CITY OF ALBUQUERQUE

June 2, 2015

**Re: Toyota Temporary Parking Lot, Grading and Drainage Plan
Certification dated –no date-
Engineer's Stamp Date 4-13-15 (C18D083)**

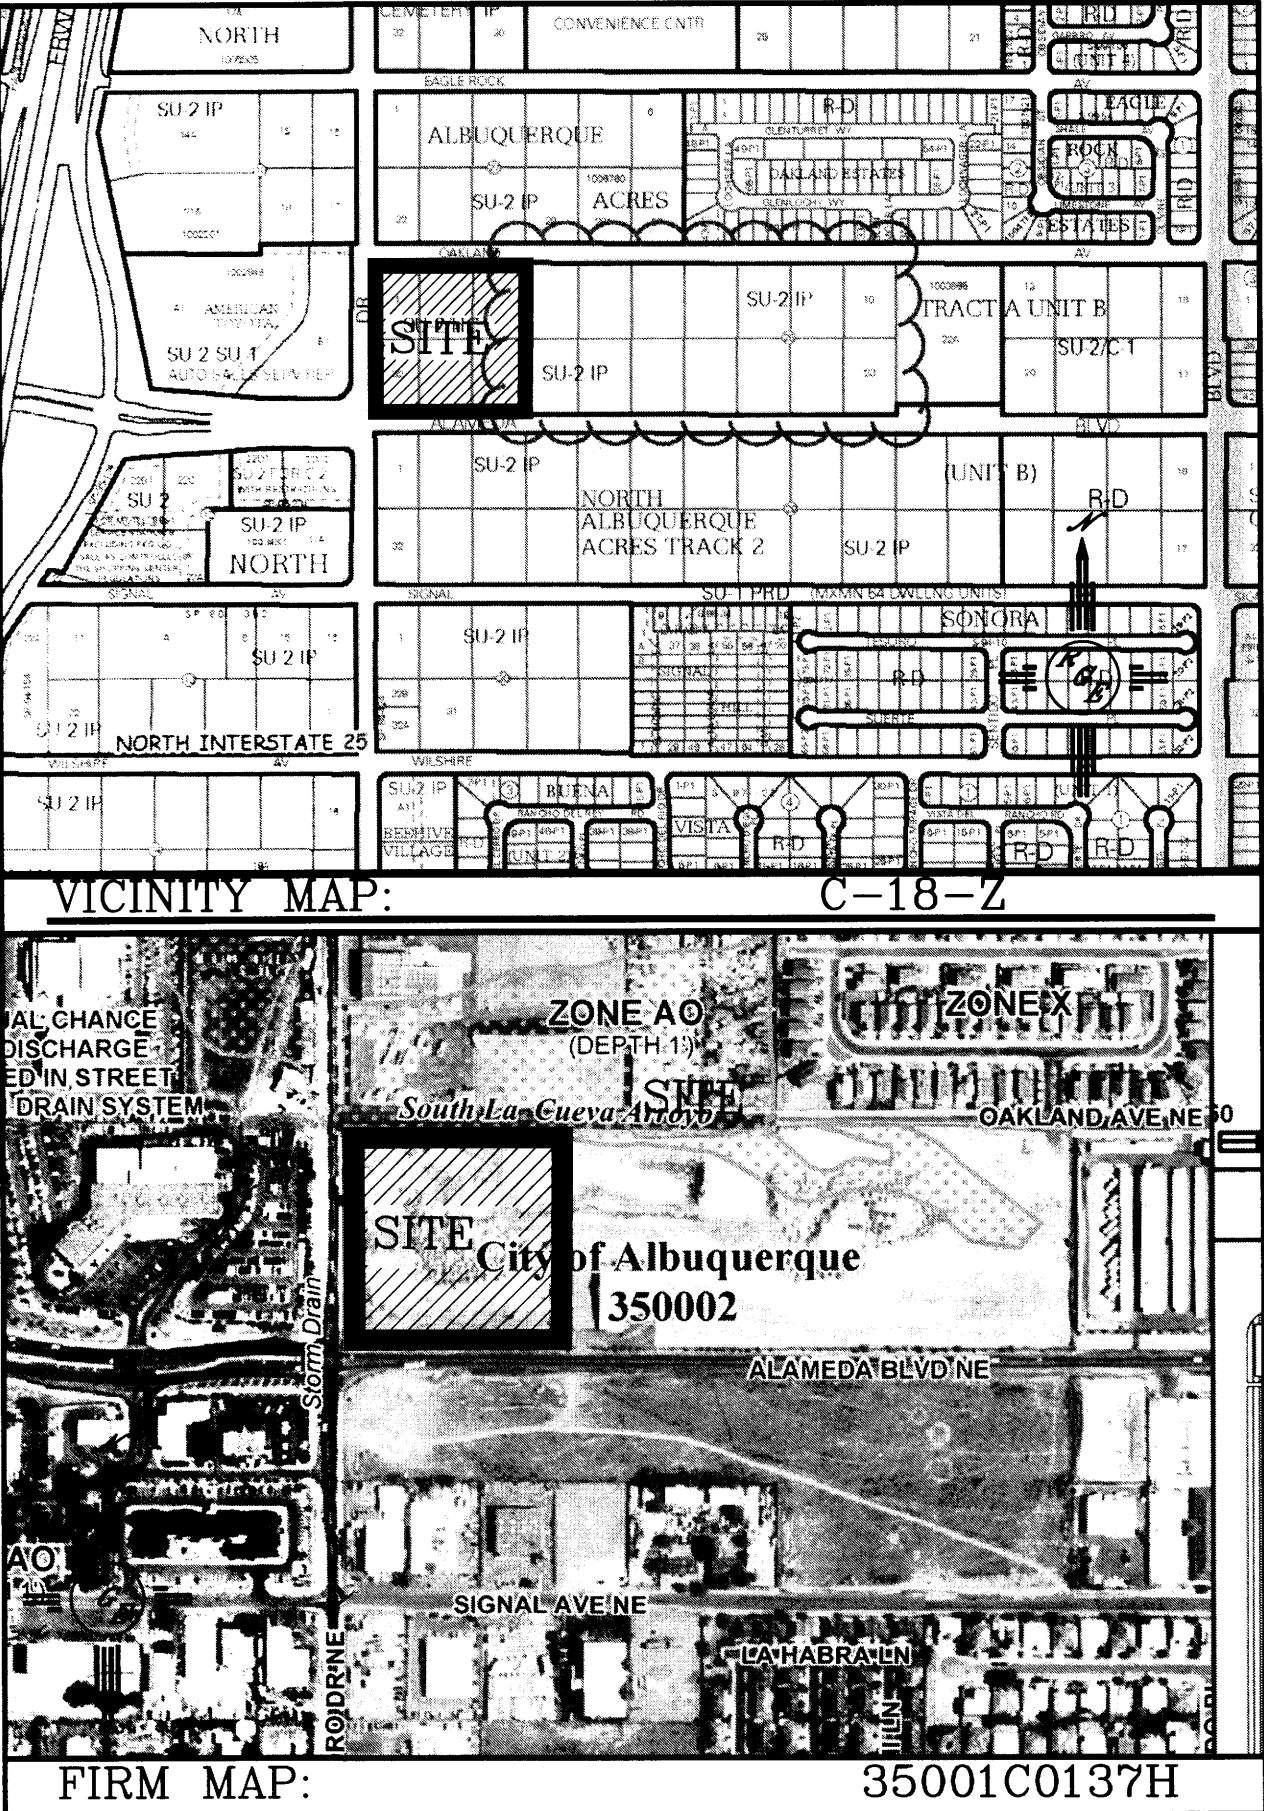
Therefore, after the drainage work in the City ROW and the site work that was not completed are complete; submit an engineer's certification on the plan dated 4-13-15. Acceptance of the certification is required prior to obtaining Certificate of Occupancy on the Toyota building across the street.
